**Application by Highways England for  
A19 Downhill Lane Junction Improvement**

**The Examining Authority's (ExA)  
Draft Development Consent Order (DCO) / DCO Commentary**

**Schedule of ExA's recommended amendments to the Applicant's draft DCO  
Revision 5 - 29 October 2019 [REP3-005]**

Drawing Title **LAND PLANS REGULATION 5(2)(i) SHEET 2 OF 2**

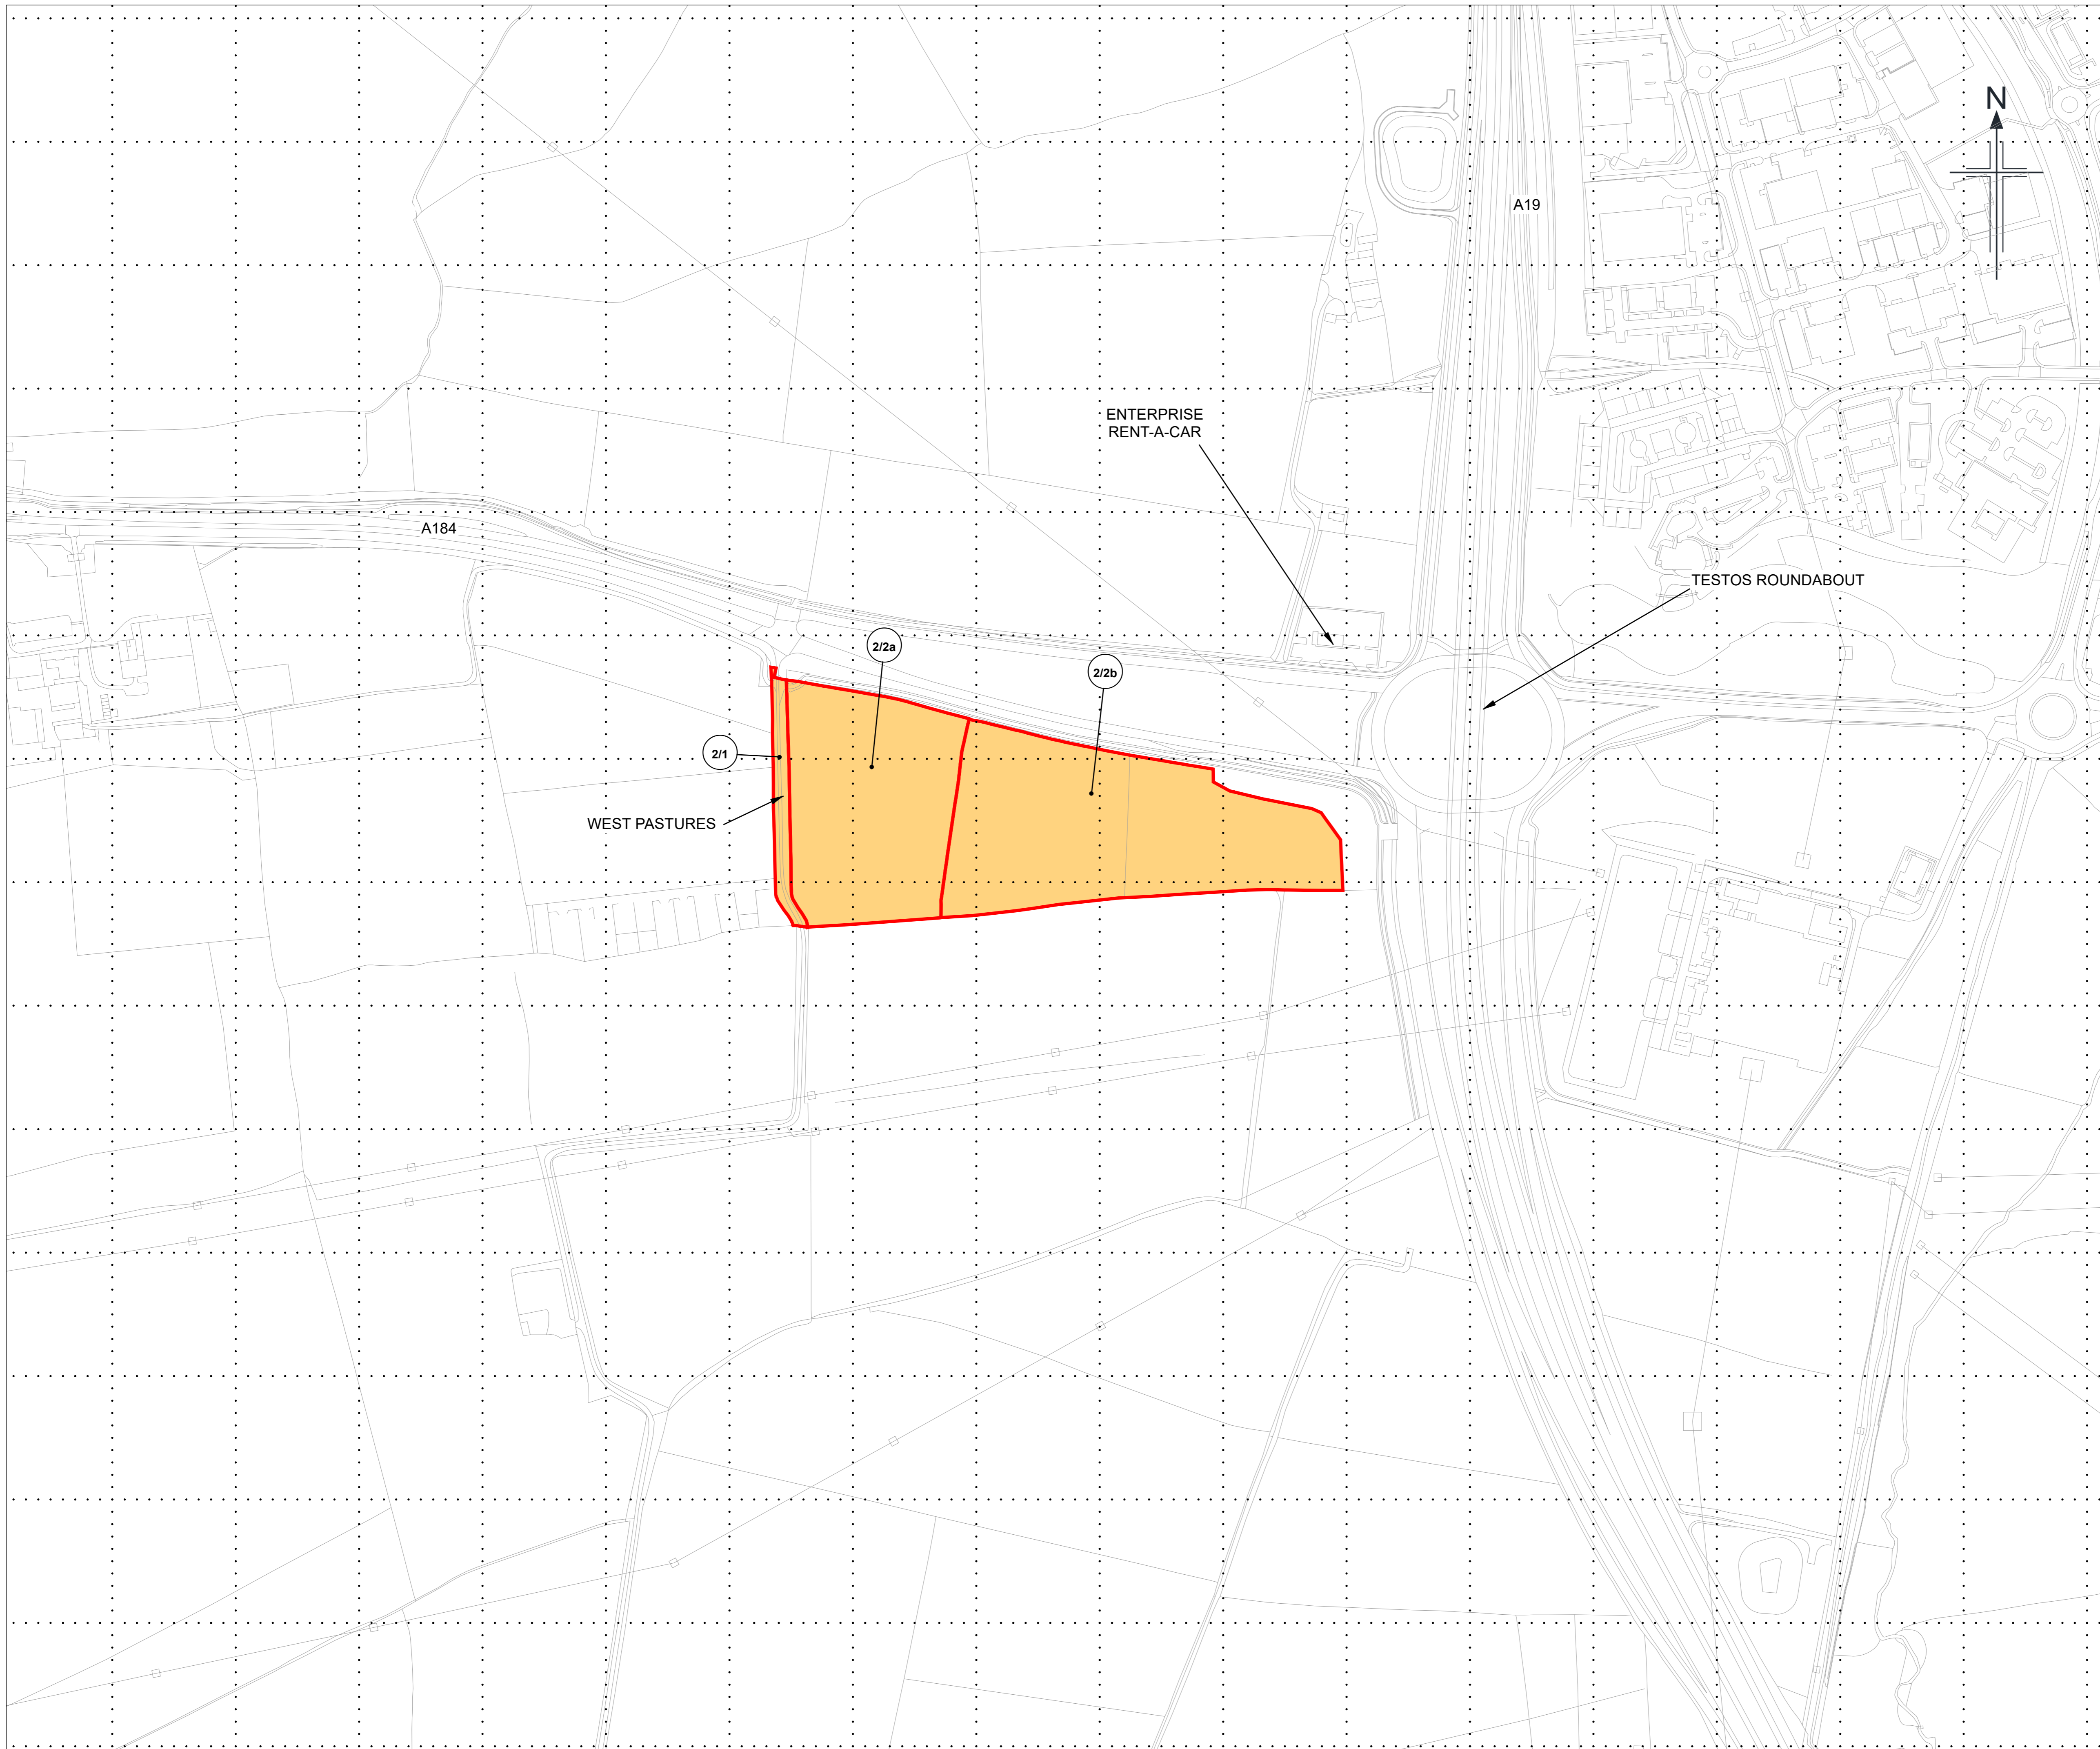
<b>Art 30</b>	<i>(1) The undertaker may only enter on and take temporary possession</i>	<i>(1) The undertaker may only enter on and take temporary possession</i>	The proposed change reflects the lack of justification for the temporary

Reference.	Text as set out in draft DCO Revision 5 [REP3-005]	ExA's Recommended Amendment	Reason and Notes
	<p><i>of the land identified as plot reference 2/1, 2/2a and 2/2b shown on the land plans for the purposes of the authorised development if the development authorised by the A19/A184 Testo's Junction Alteration Development Consent Order 2018(b) (the "Testo's Order") has commenced and the main construction compound referred to as Work No. 31 in Schedule 1 to the Testo's Order has not been vacated at the commencement of development authorised by this Order.</i></p> <p><i>(2) Where the undertaker is in possession of the land identified as plot reference 2/1, 2/2a and 2/2b on the land plans for the purposes of the authorised development, the undertaker may enter upon and take temporary possession of the specified land for the purposes of the authorised development provided it does not carry out construction activities on that land.</i></p> <p><i>(3) In this article— "construction activities" means any material operation (as defined in</i></p>	<p><i>of the land identified as plot reference 2/1, 2/2a and 2/2b shown on the land plans for the purposes of the authorised development if the development authorised by the A19/A184 Testo's Junction Alteration Development Consent Order 2018(b) (the "Testo's Order") has commenced and the main construction compound referred to as Work No. 31 in Schedule 1 to the Testo's Order has not been vacated at the commencement of development authorised by this Order.</i></p> <p><i>(2) Where the undertaker is in possession of the land identified as plot reference 2/1, 2/2a and 2/2b on the land plans for the purposes of the authorised development, the undertaker may <u>not</u> enter upon and take temporary possession of the specified land <u>or carry out construction activities on that land.</u></i> <del><i>for the purposes of the authorised development provided it does not carry out construction activities on that land.</i></del></p> <p><i>(3) In this article—</i></p>	<p>possession of Plot 1/14b in the event that Plots 2/1, 2/2a and 2/2b were to be used.</p> <p>See also ExQ2.5.4.</p>
